Local Land Services North West

2 February 2021

RE: North West Local Land Services Comments on State Significant Infrastructure Project: Inland Rail – Narromine to Narrabri (Application No. SSI-9487)

Figure A1.2 Key features of the proposal (map 1)

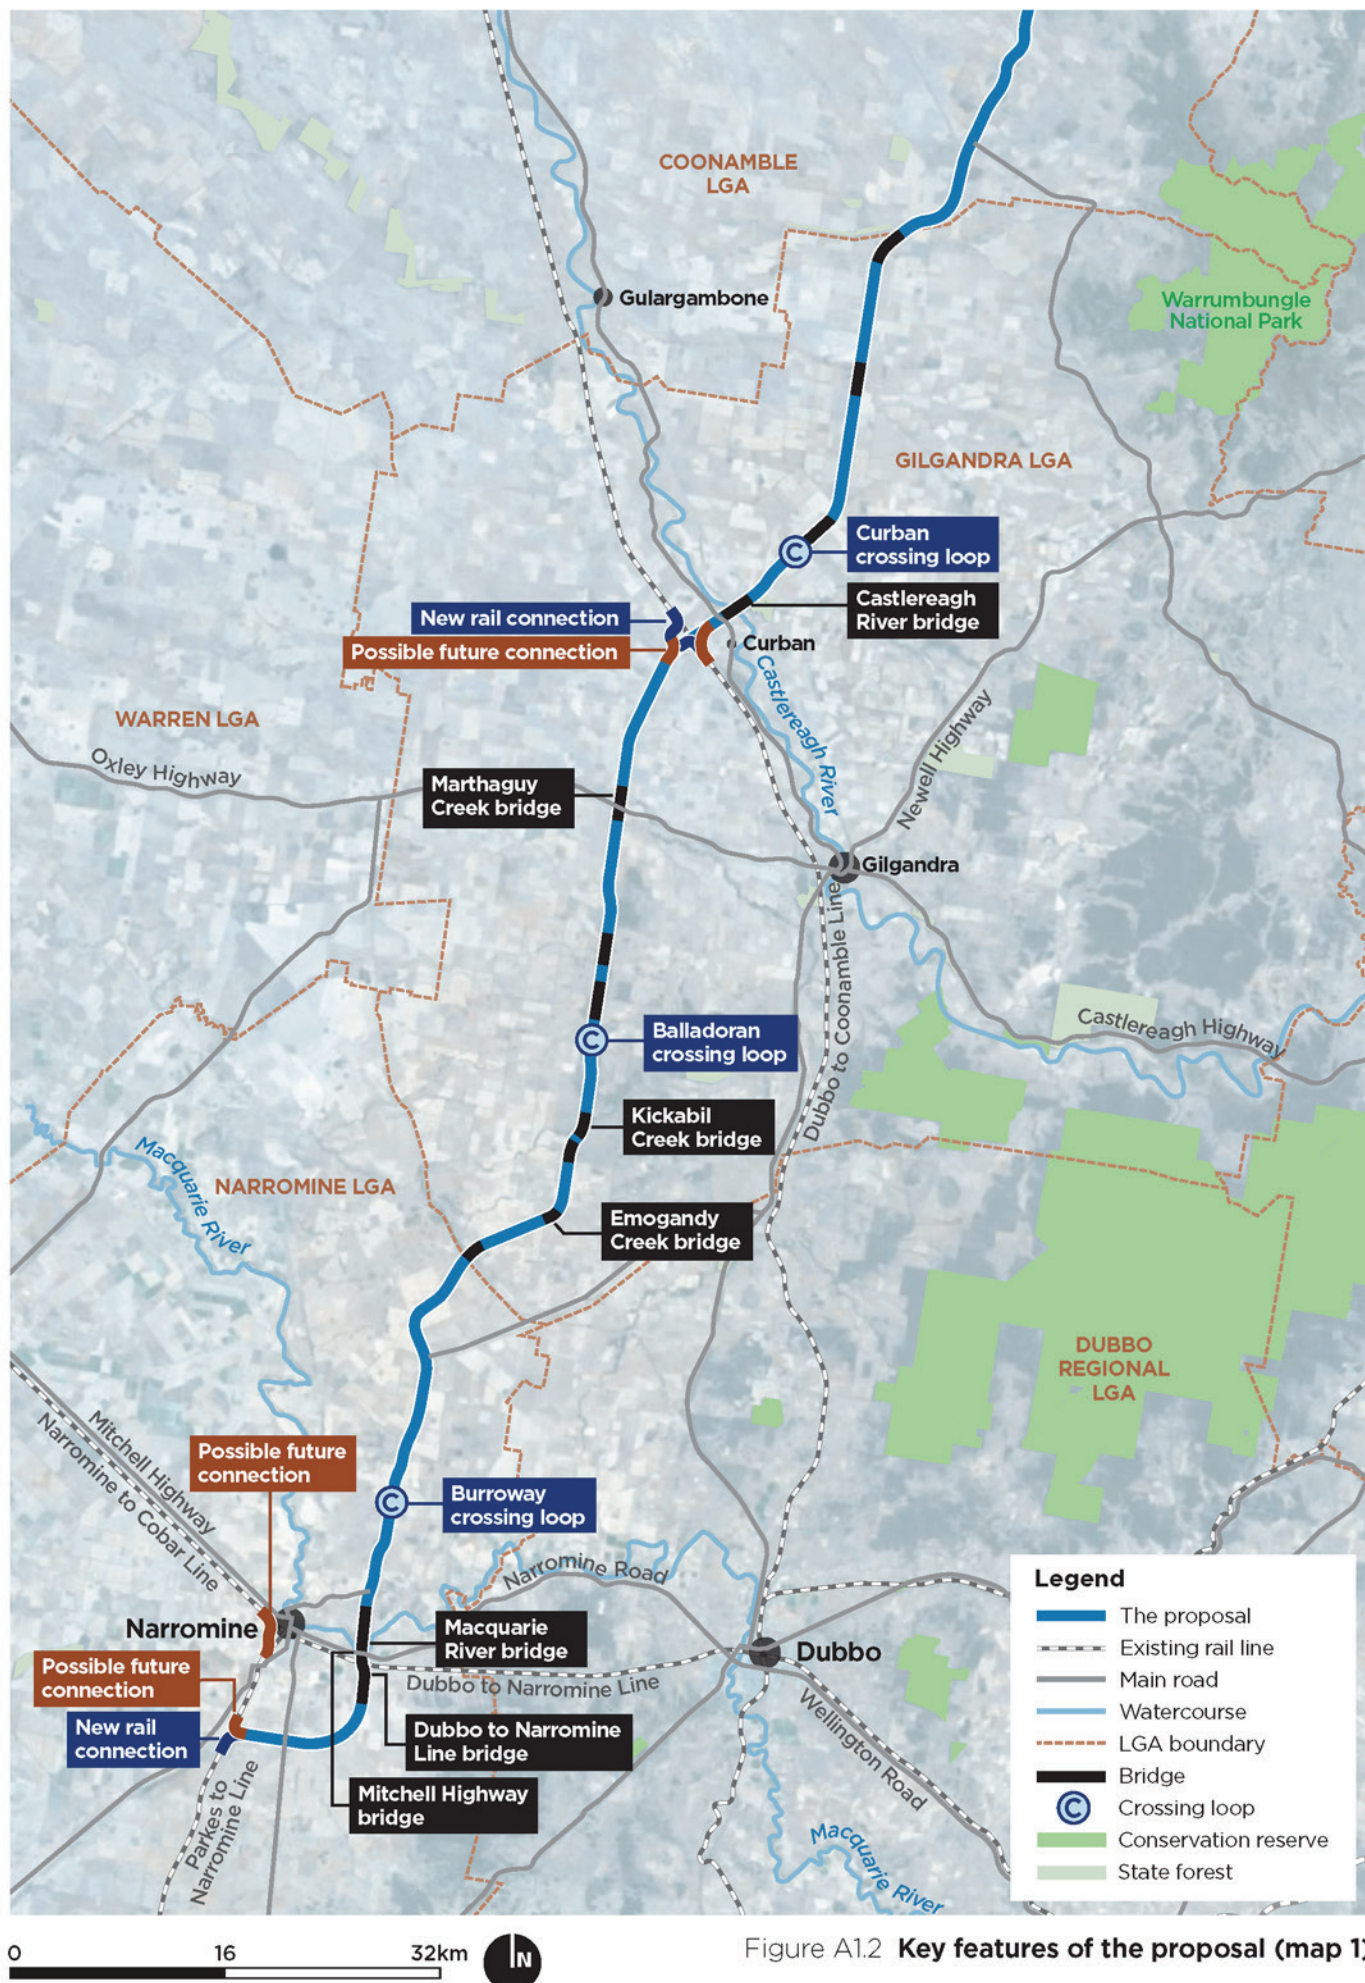
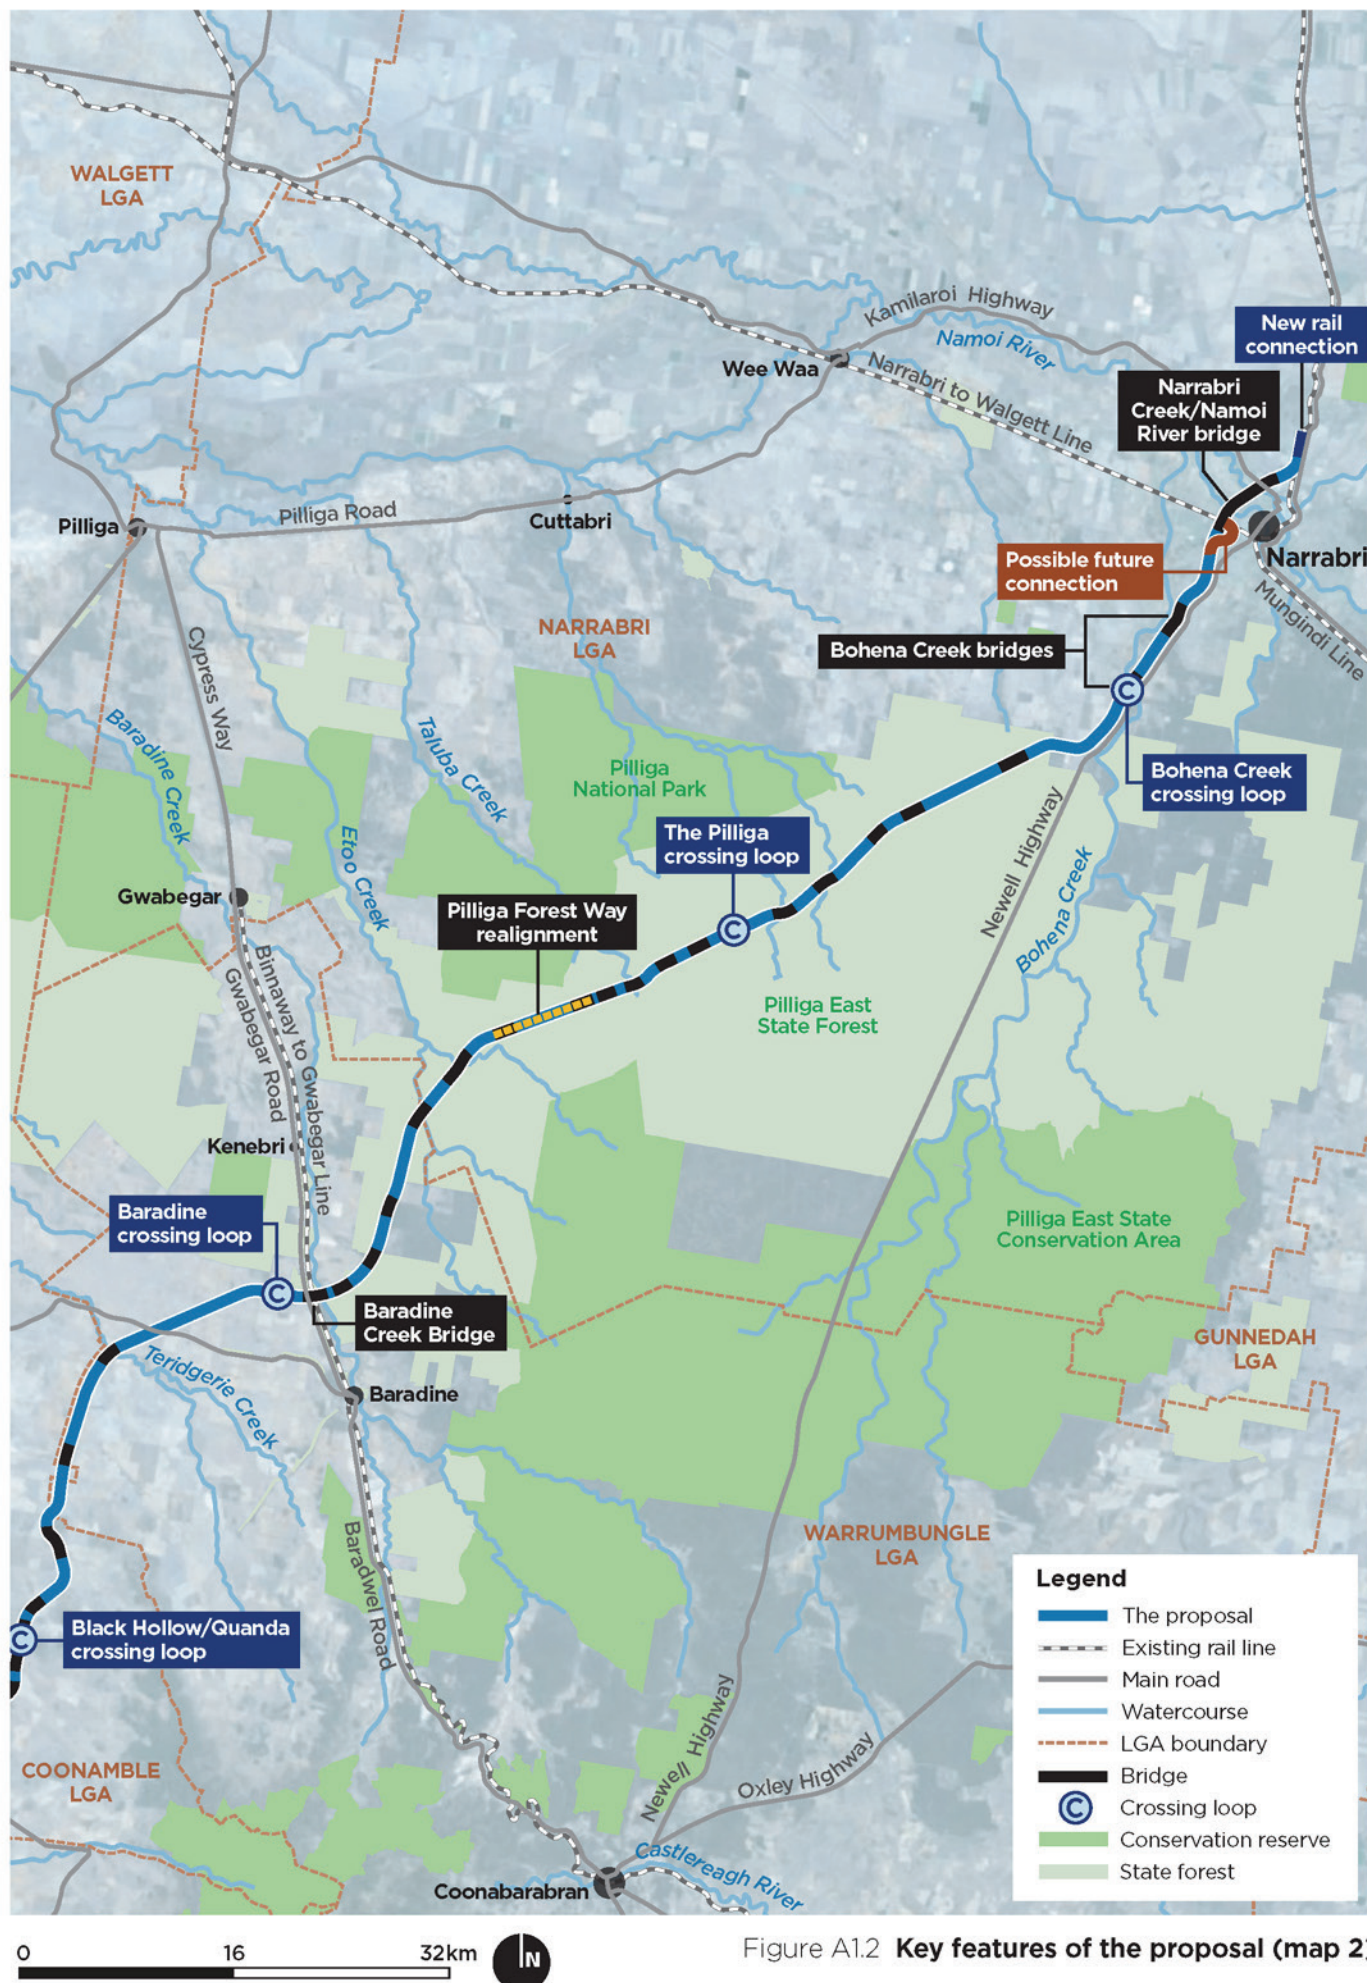
1. Rail corridor alignment through TSR R27999 (Arrow TSR)

- The rail corridor alignment is proposed to traverse Folios 6/1195493 and 7/1195493 immediately north of Narrabri. These Lots are a key component of TSR R27999 which facilitates the important movement of walking livestock within the region.

- R27999 forms a major junction and connection point for walking stock at the regional level, and as a result, the loss of the ability to move stock along these Lots will have a major adverse impact on the functionality TSR network.

- The current proposal is for ARTC to align the corridor to the south-eastern side of the Lots which will create an approximate 40m wide and 700m long corridor for livestock to walk through.

- It is likely stock, including large mobs of cattle over 1,000 head, will not always move through the long corridor quick enough to avoid all passing trains. The close proximity, size and speed of the proposed trains are expected to shock and panic the stock resulting in crushing, collision and probable loss of life to livestock, stock managers and road users such as those on the high-use adjoining Newell

Highway. These risks extend to livestock within holding yards in close proximity to the passing trains.

- As a result, given there is no feasible mitigation, it is not possible to run the rail corridor through the identified Lots without raising the risk to TSR users and livestock to an unacceptable level.

1. As a condition of approval, Folios 6/1195493 and 7/1195493 are to be excluded from the rail corridor alignment requiring ARTC to seek an alternative and more appropriate rail corridor placement immediately north of Narrabri.
